Please ask for: Ms Iqraa Malik
Email: iqraa.malik@terraquest.co.uk
Telephone: 01212341390
Our Ref: FG/92/21/HH
Your Ref:
Date: 24th May 2021

Application for Planning Permission for Works or Extension to a Dwelling

Development: Erection of single storey rear and side extension following demolition of existing detached garage
Location: 22 Onslow Drive Ferring BN12 5RS

BLOCK PLAN 1:200

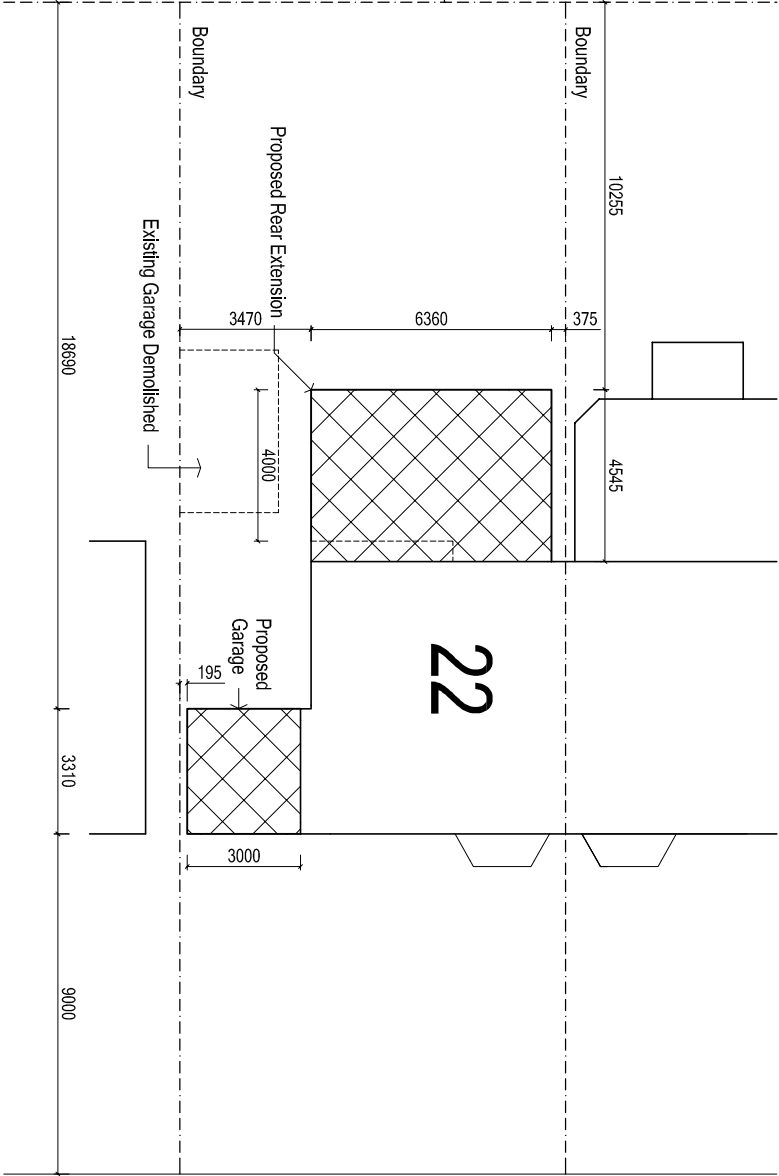
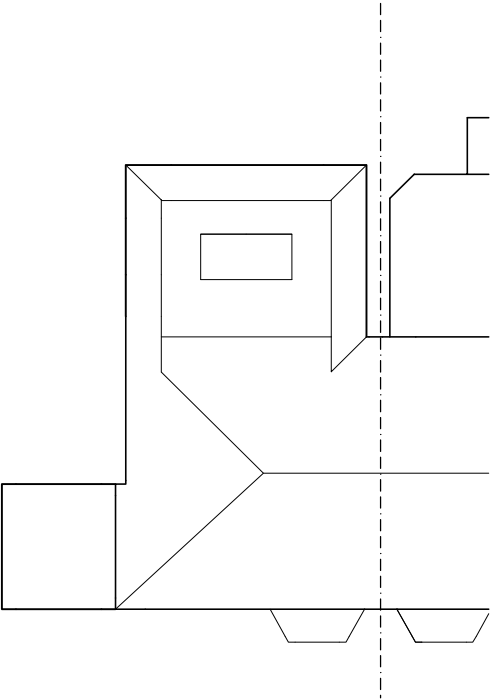
Block Plan

You are required to have dimensions from the proposed extension(s) to all site boundaries. Please amend
